**Application by Mona Offshore Wind Limited for Mona Offshore Wind Farm**  
**The Examining Authority's written questions and requests for information (ExQ2)**  
**Issued on 19 November 2024**

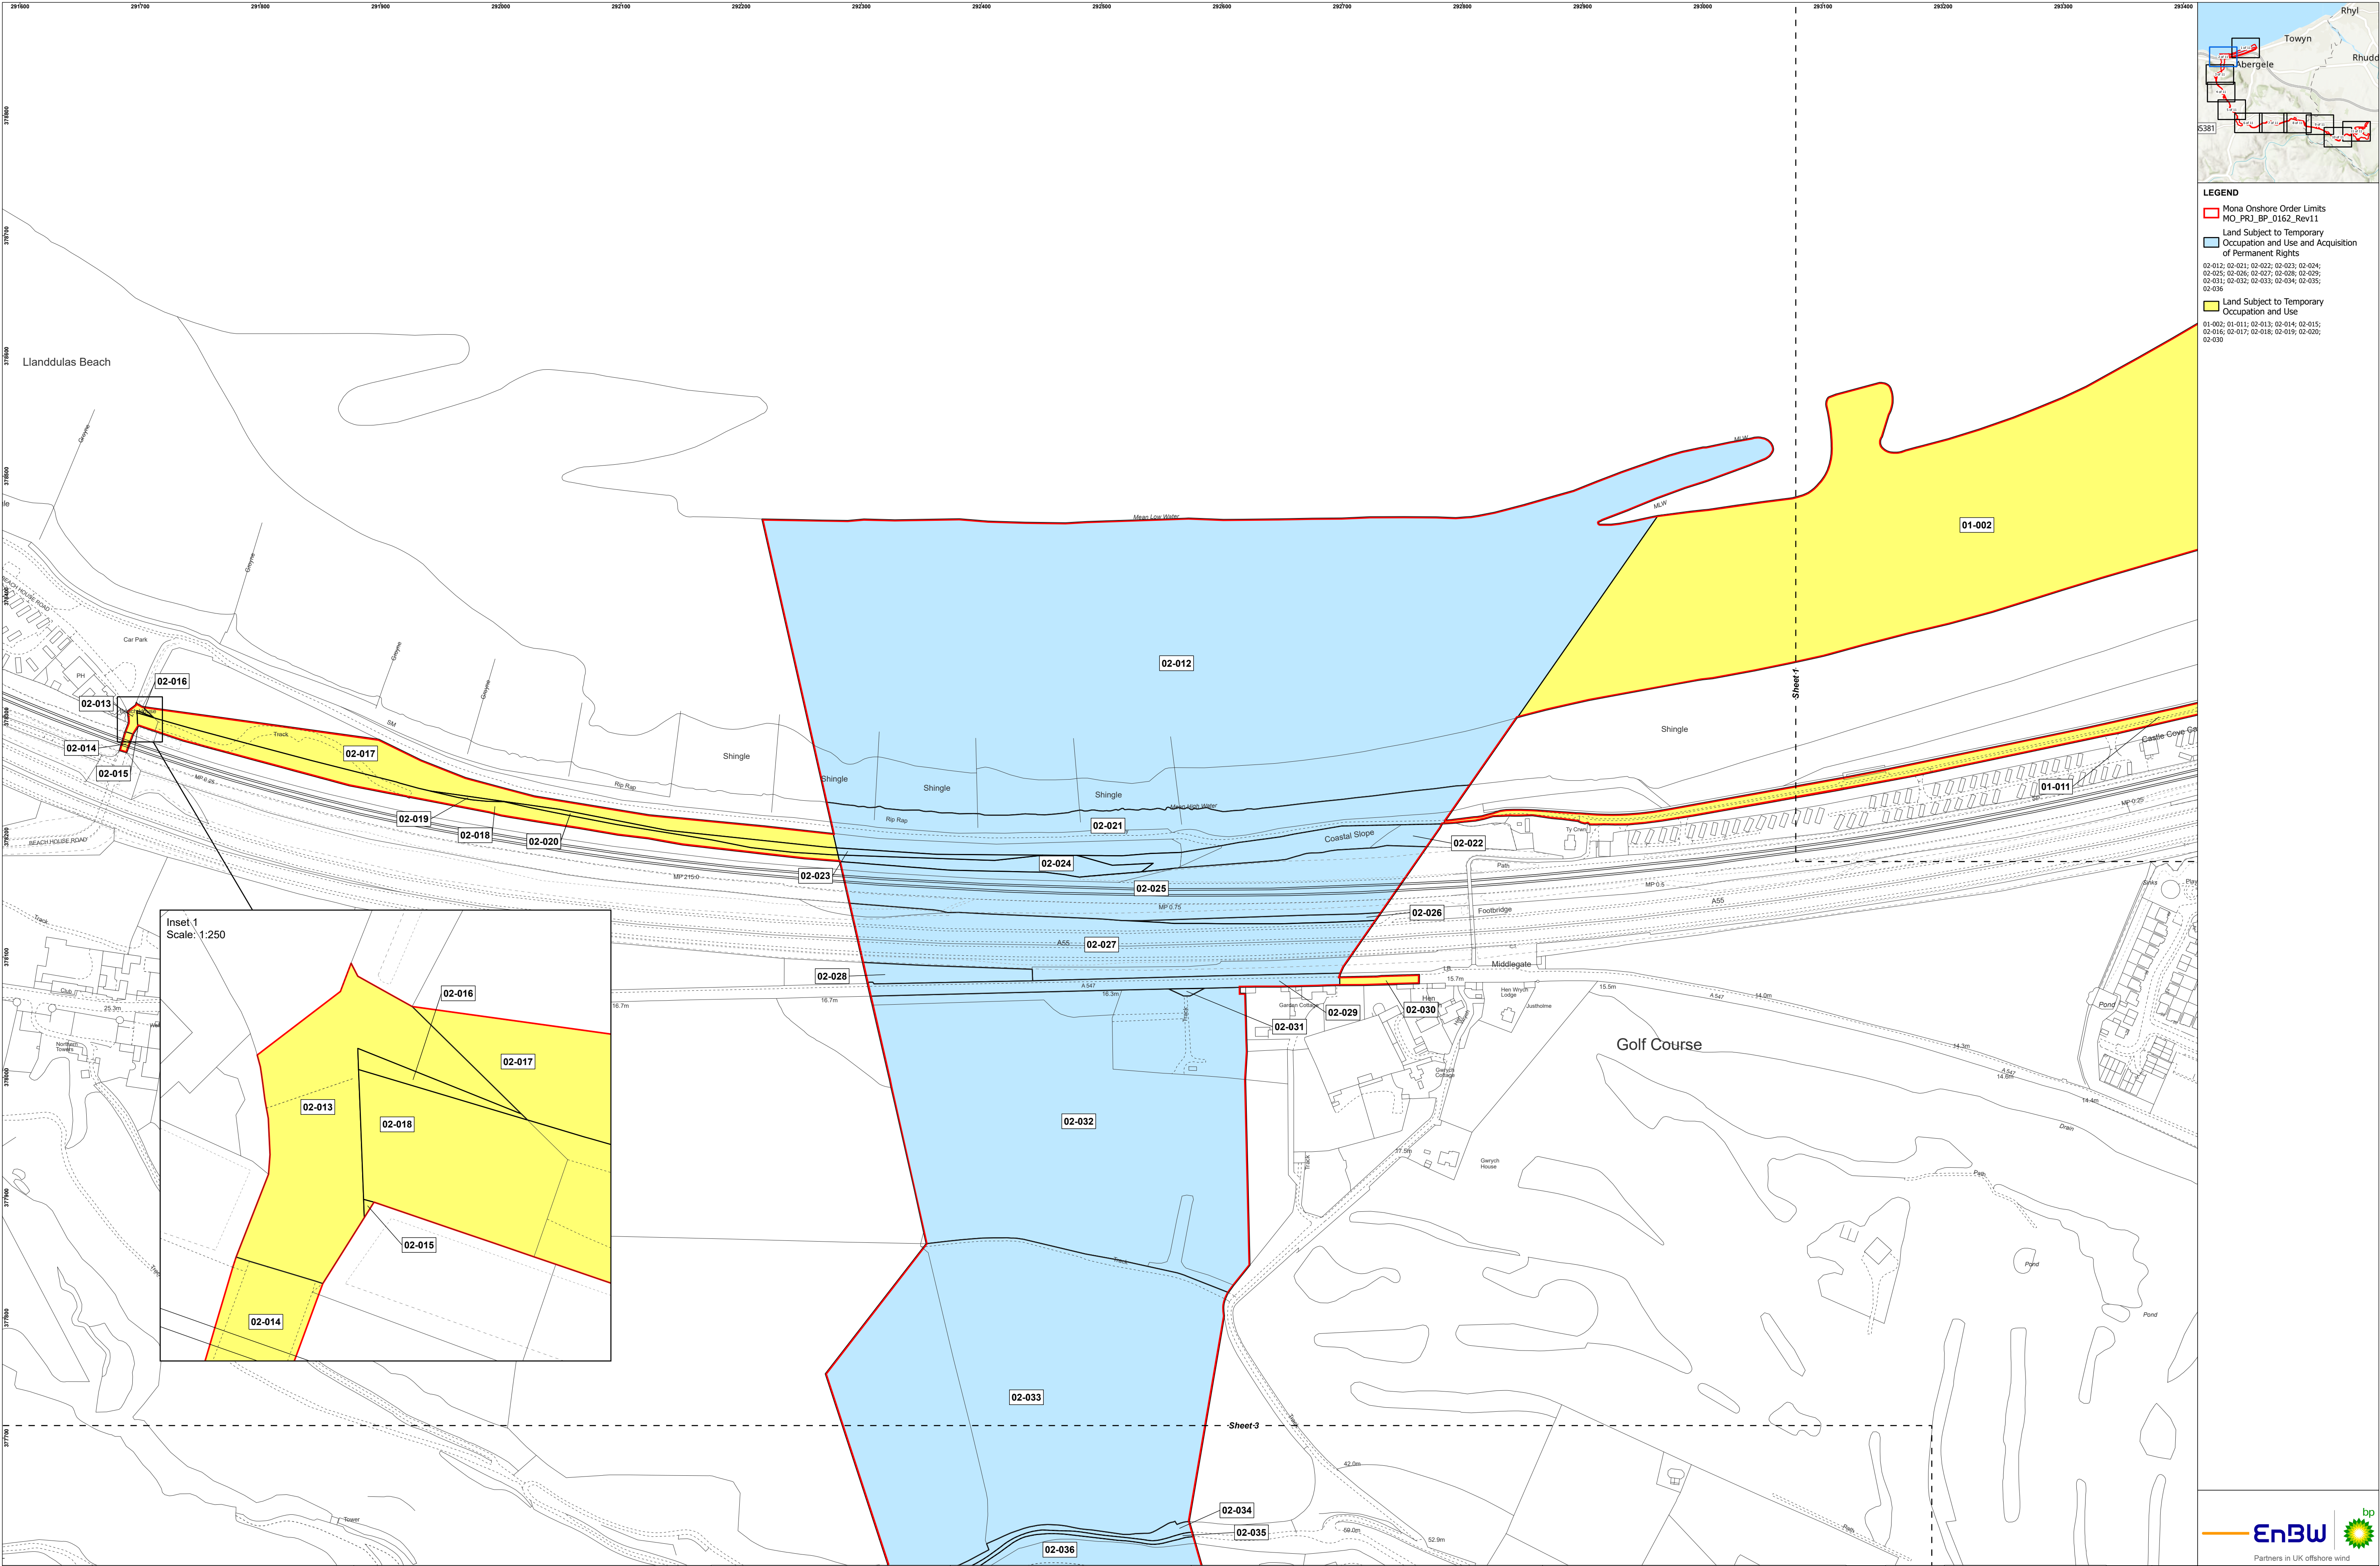
<b>ExQ2</b>	<b>Question to:</b>	<b>Question:</b>
	Building & Civil Engineering Limited	In your submission on your client's' behalf [REP4-117] you refer to the 'Easement strip'. Using either the Land Plan Onshore – Sheet Number 2 [REP1-004] or Works Plan - Onshore Sheet 2 [AS-003], please annotate either with the area that you are referring to.
Q2.6.20	Richard Fearnall on behalf of Michael and Sally Leach	<b>Michael &amp; Sally Leach</b> Where it deals with potential interference with your land rights, and bearing in mind that the Secretary of State cannot intervene in respect of the award of compensation, is there anything that you want to add to your earlier submissions in respect of the Applicant's Response to Richard Fearnall on behalf of Michael and Sally Leach ExQ1 Responses ([REP4-077], REP3-113.4)?
Q2.6.21	DPMC on behalf of Hefin Williams	<b>Hefin Williams</b> Is there anything that you want to add to your existing submissions on your client's behalf in respect of the Applicant's Response to Davis Meade Property Consultants on behalf of Hefin Williams ExQ1 Responses [REP4-066]?

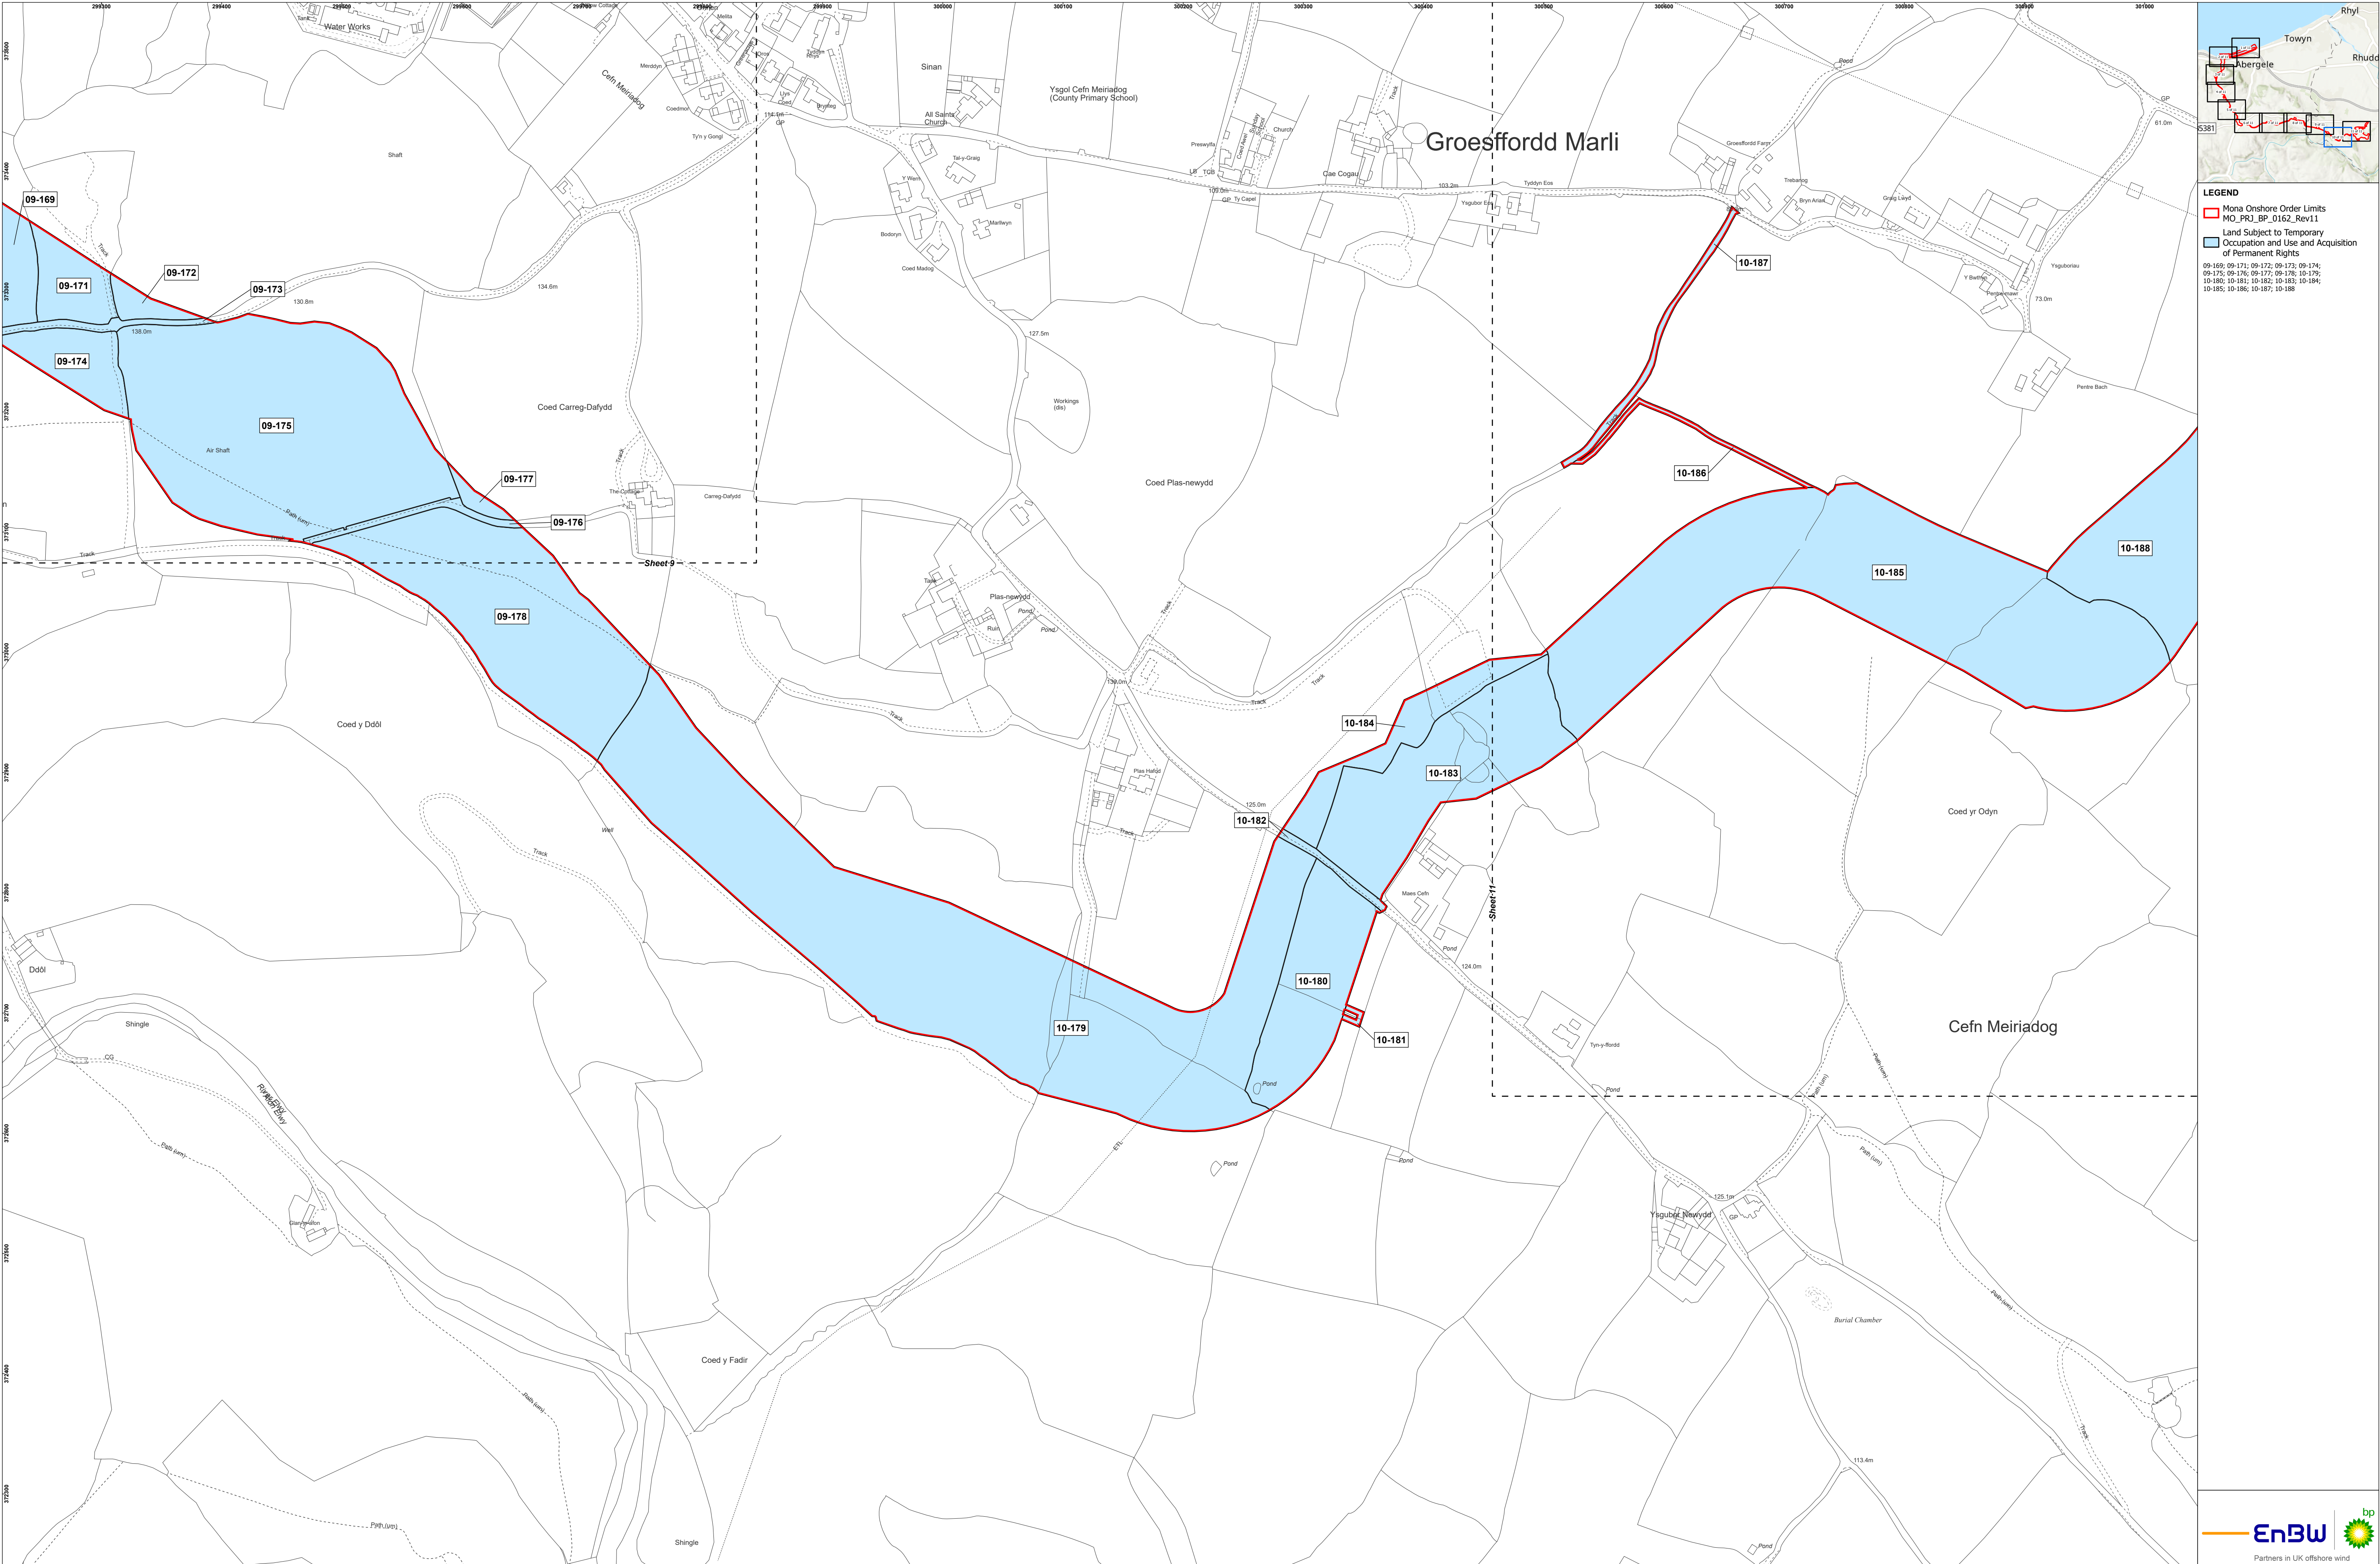
Q2.124	CBCC DCC	<p><b>Public Rights of Way</b></p> <p>In you LIR [REP1-049] specific concerns were raised about the Proposed Development's impact on PRoWs. The Applicant addressed these in its response your LIR ([REP2-085, REP1-049.48 &amp; REP1-049.157). Have you any outstanding associated concerns?</p>
Q2.125	DCC	<p><b>'The Old Lane', Groesffordd Marli</b></p> <ul style="list-style-type: none"> <li>From your perspective, what is the legal status of Plot no. 10-187 as shown on the BoR [REP3-006]?</li> <li>If it is not part of a designated Public Bridleway, are there plans to do so?</li> <li>If it is to be designated as such, when is this likely to happen?</li> </ul>
Q2.126	The Applicant	<p><b>'The Old Lane', Groesffordd Marli</b></p> <p>Will you be amending your Outline Public Rights of Way Management Strategy [REP2-070] in respect of Plot 10-187 as shown on the Land Plan (Onshore) [REP1-004]?</p>
